28 August 2024

Our Ref: 24/238502
Our Contact: Robert McKinlay (02) 9366 3724

RE: Exhibition of Modification 4 to SSD-11429726 at 161-173 Princes Highway, Arncliffe

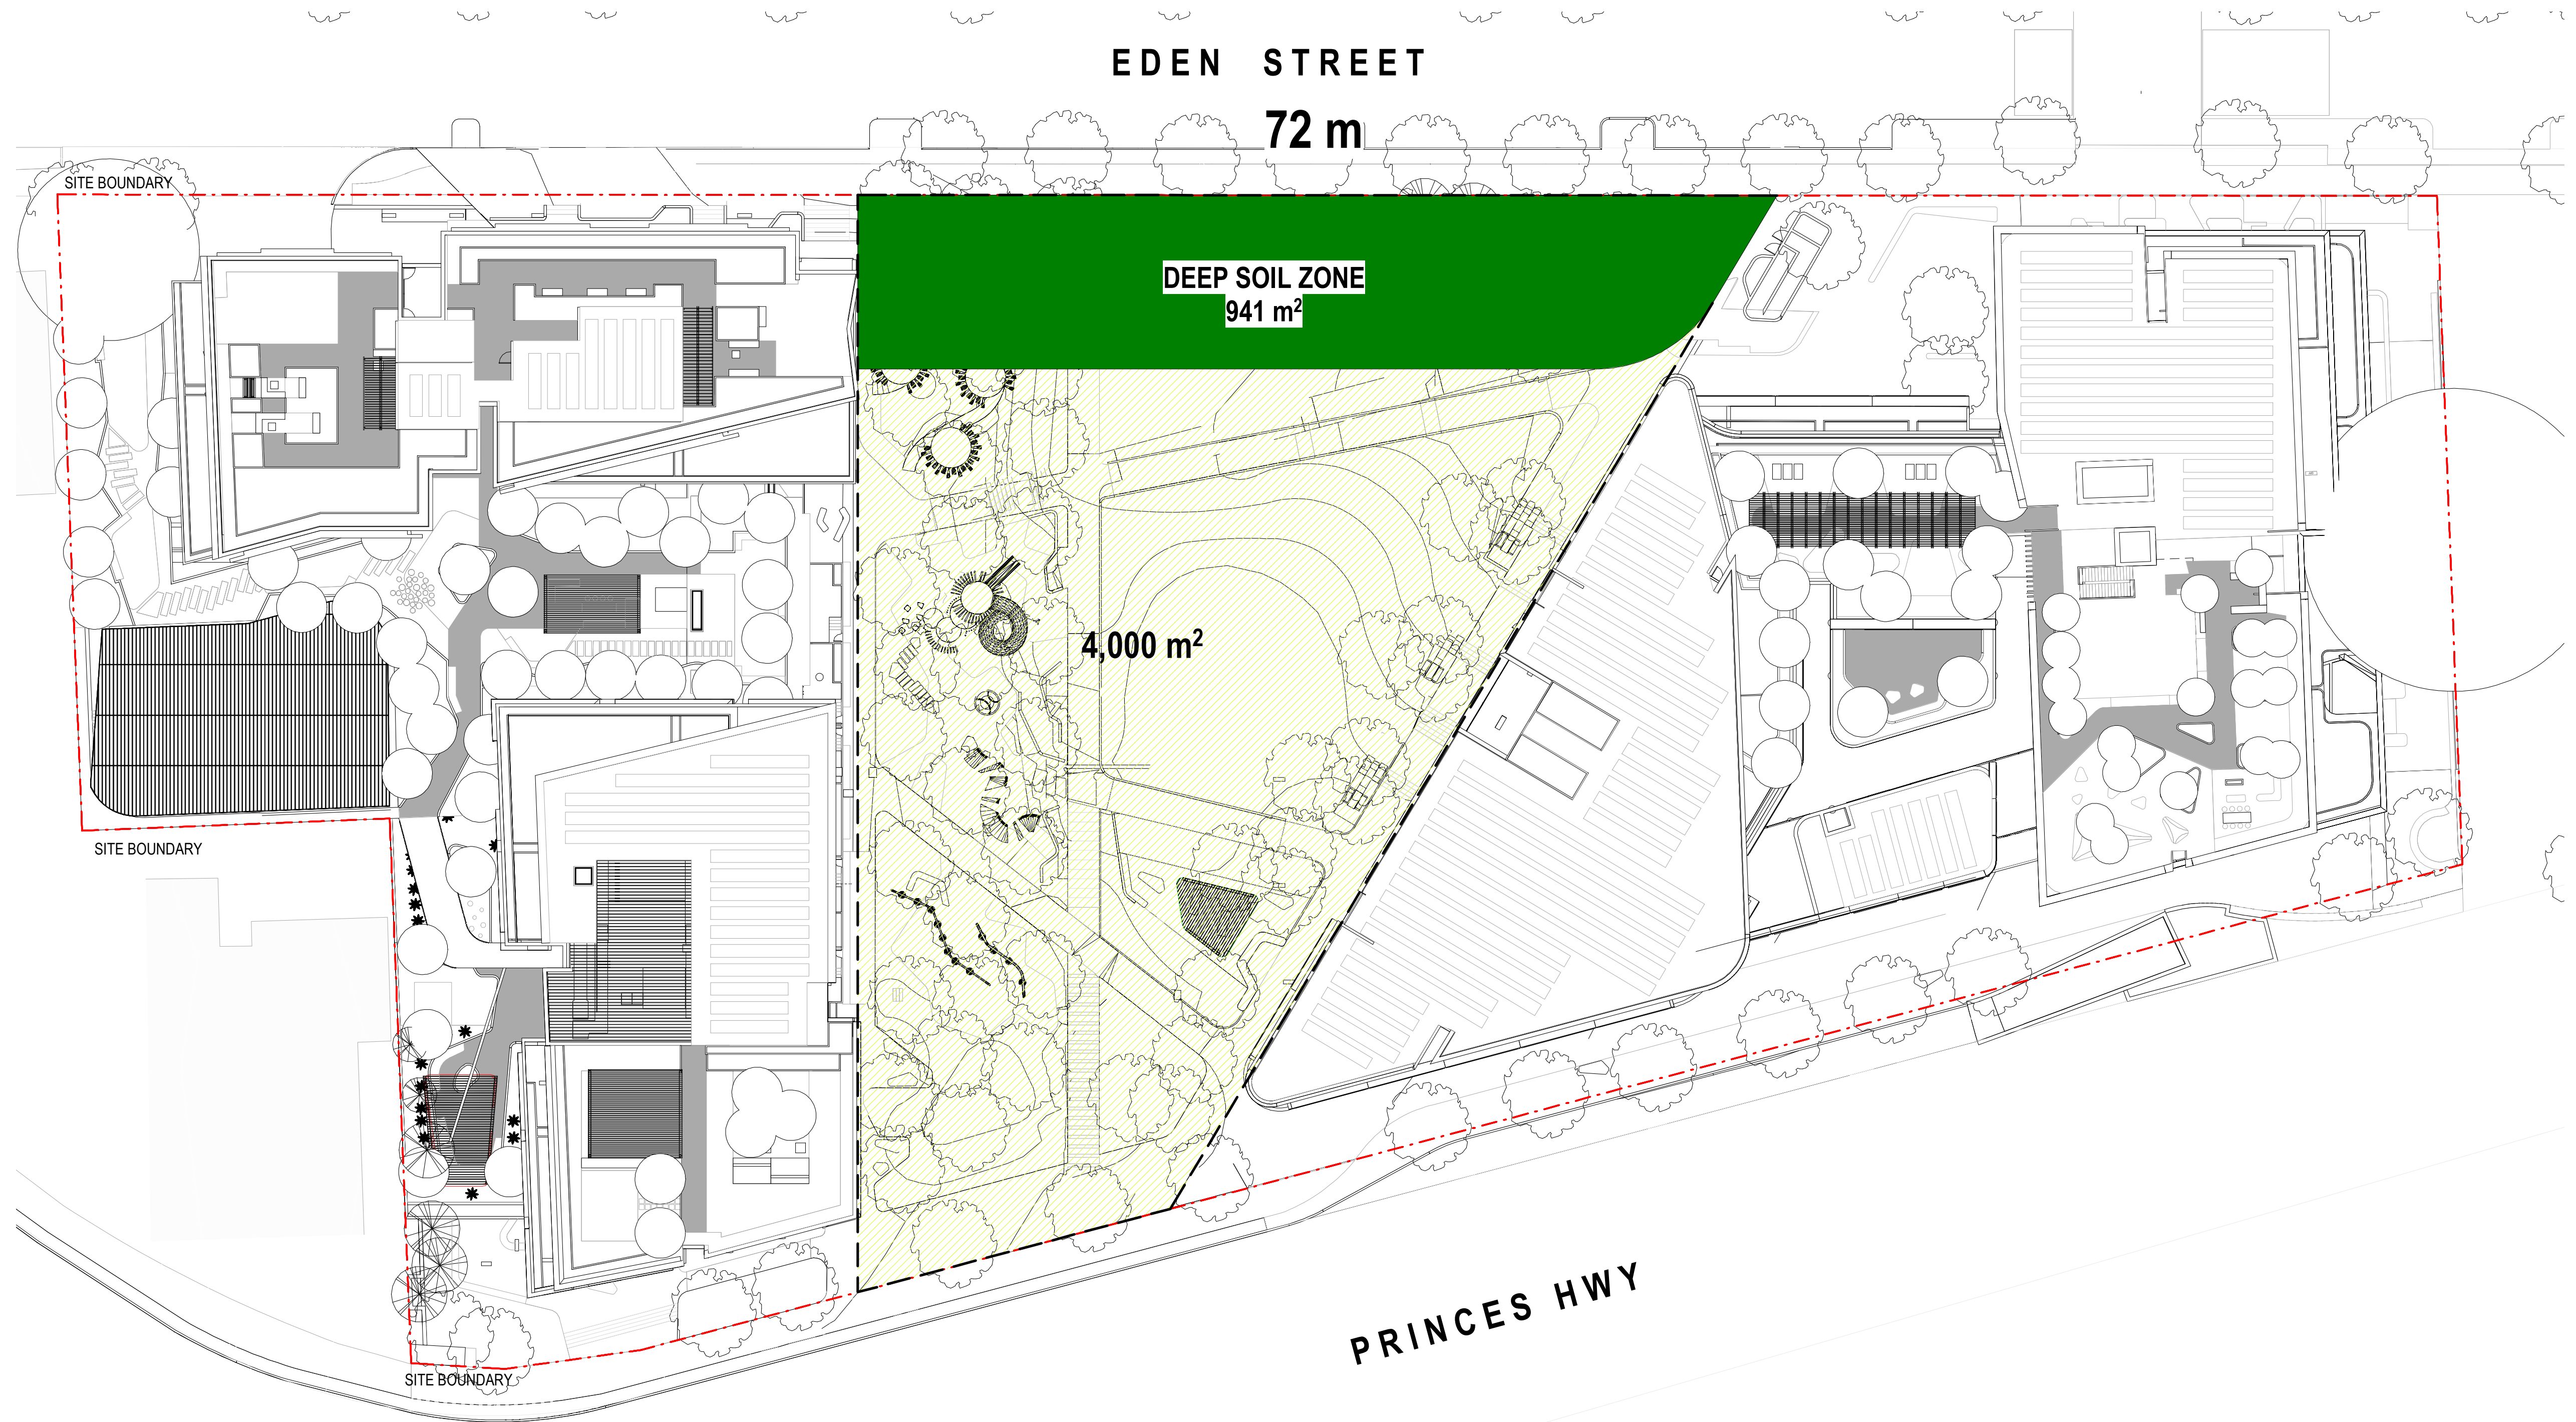
The new substation location does not appear to be reflected in the Deep Soil Diagram (Drawing DA 4300) or in calculations of the amount of deep soil area provided in the modification report. An excerpt is provided below:

In addition to the details for siting of the substation, the proposal should provide an updated Deep Soil Diagram and deep soil area calculation to demonstrate whether compliance is achieved.

Figure 5 Community facility amenities location, as approved (top) and as amended (bottom)

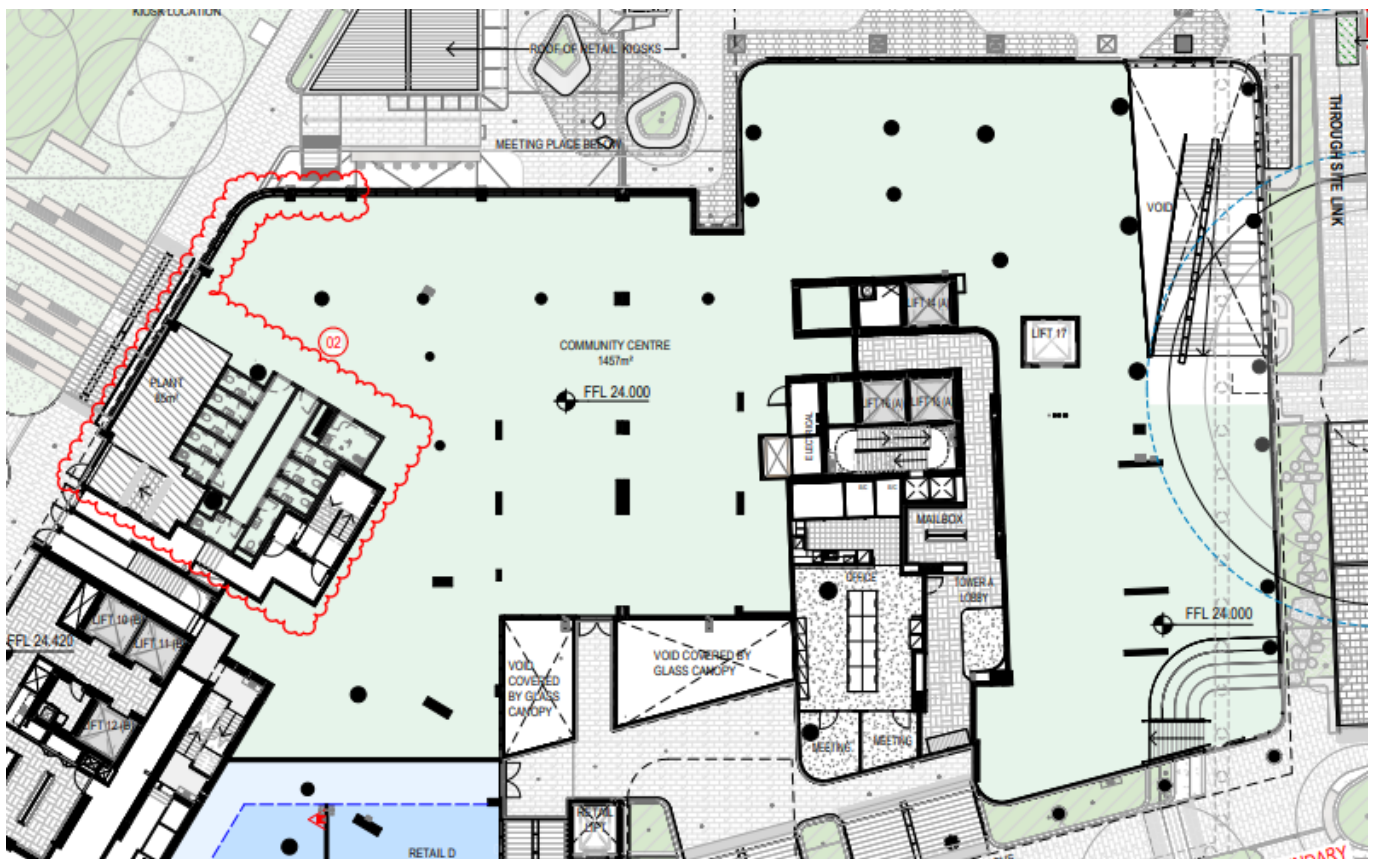
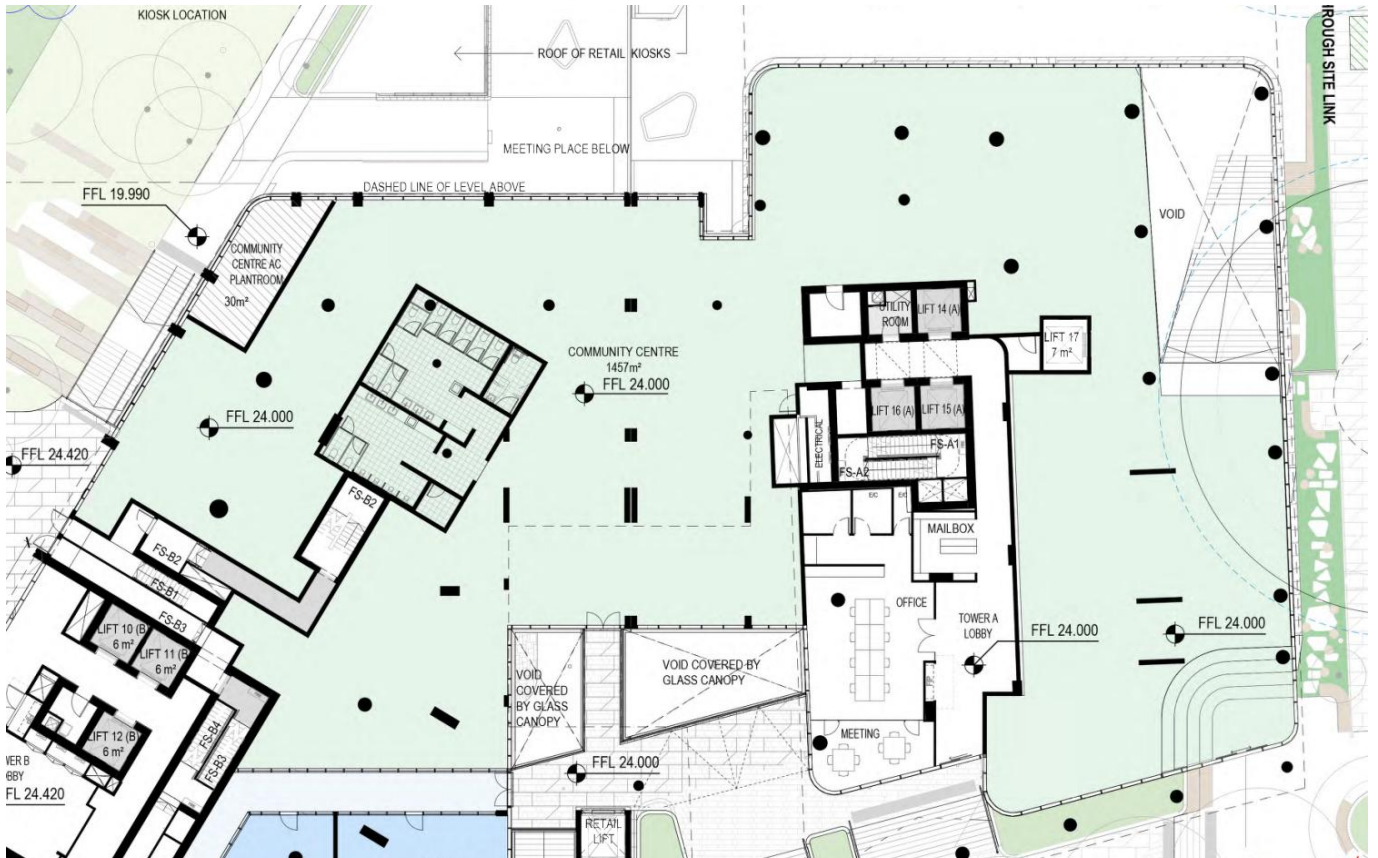
The plans should be amended to remove all detail showing the layout and features of the community facility bathrooms.
